Our ref: St Philip's Christian College, Cessnock campus (SSD-10360337)

Subject: Response to Submissions

The exhibition of the development application for the alterations and additions to St Philip's Christian College, Cessnock campus (SSD-10360337) including the Environmental Impact Statement ended on 16 March 2022.

4347 CD4401 RevB 18.01.22 O - Aquatic Centre - Ground Floor Plan

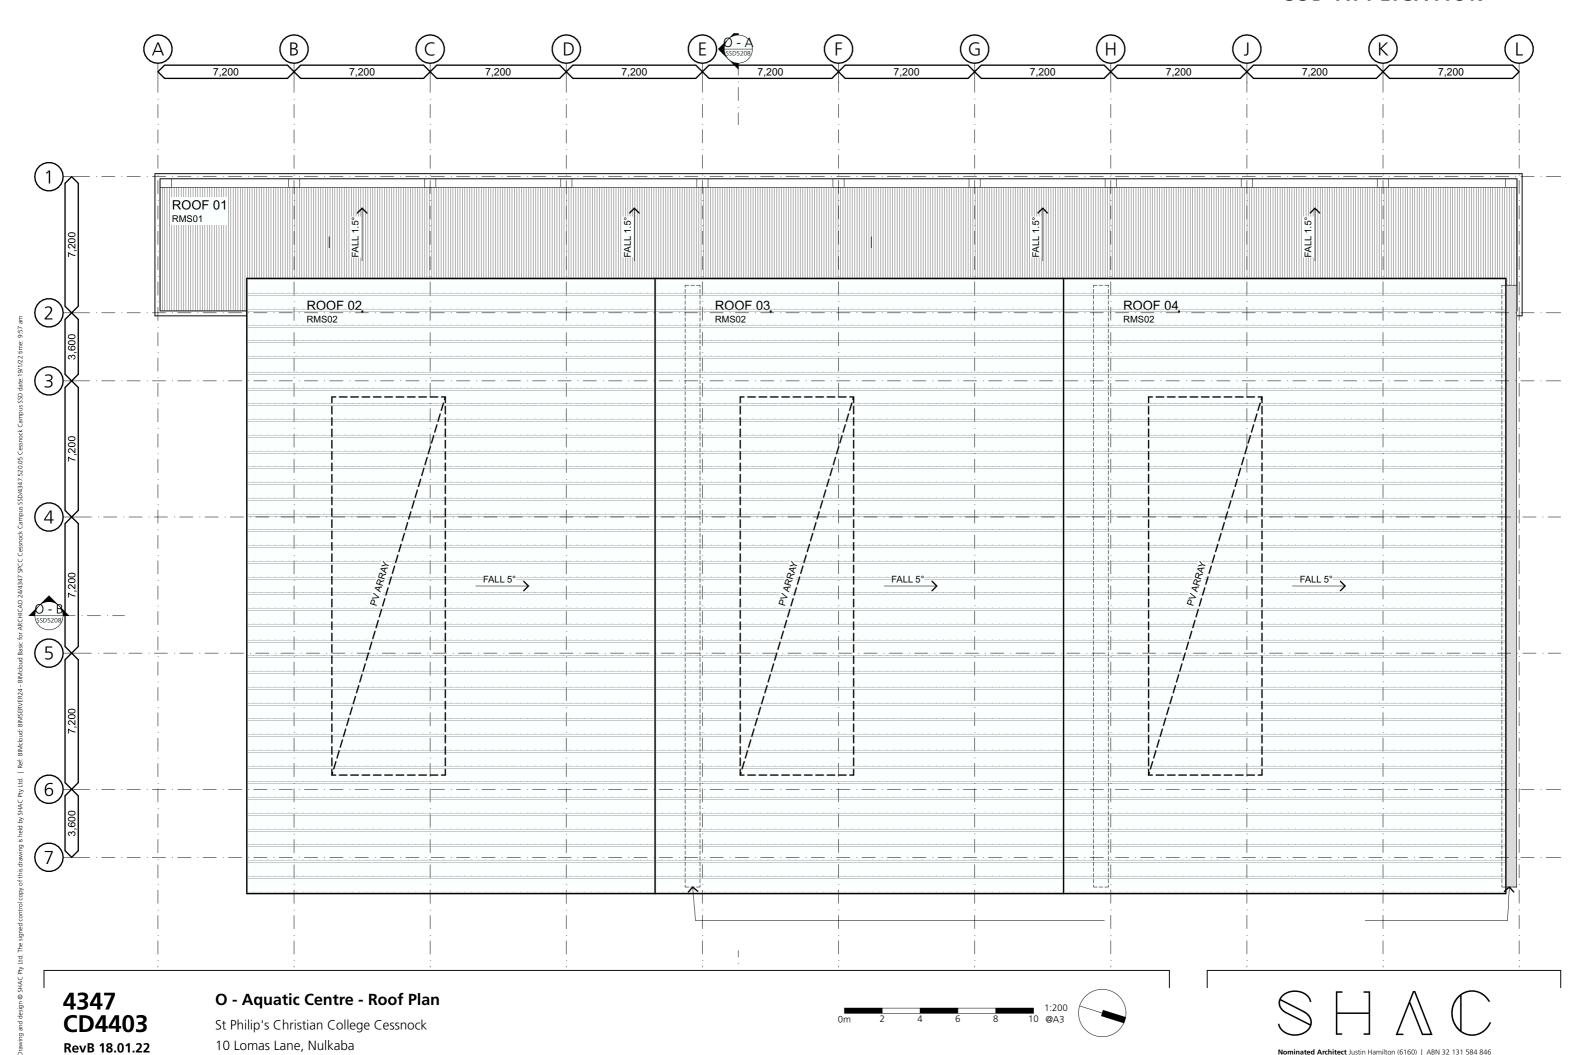
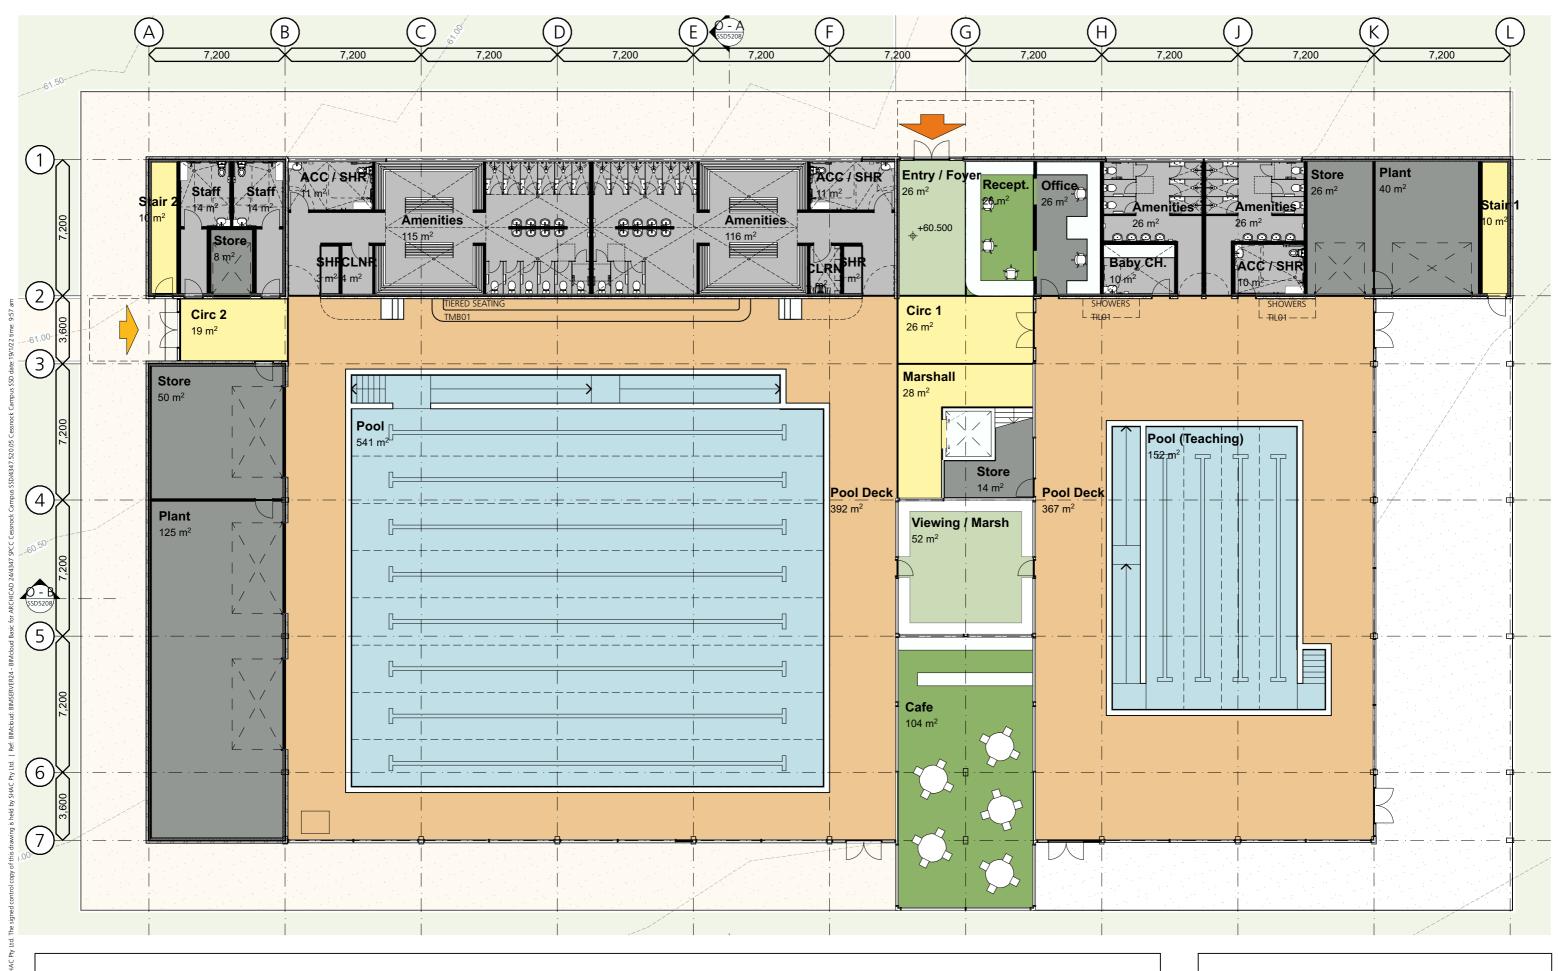
2. Proposed Aquatic Centre – definition

This component of the application is, therefore, wholly prohibited as indoor recreation facilities are not a permissible use in the RU2 Rural Landscape zone under the CLEP 2011. The RtS must confirm if the proposed Aquatic Centre forms part of the SSD application as either:

- alterations and additions to the existing school, consistent with SRD SEPP, or
- a recreation facility (indoor) as defined under the CLEP 2011 (i.e. to be assessed as a separate component to the alterations and additions to the existing school).
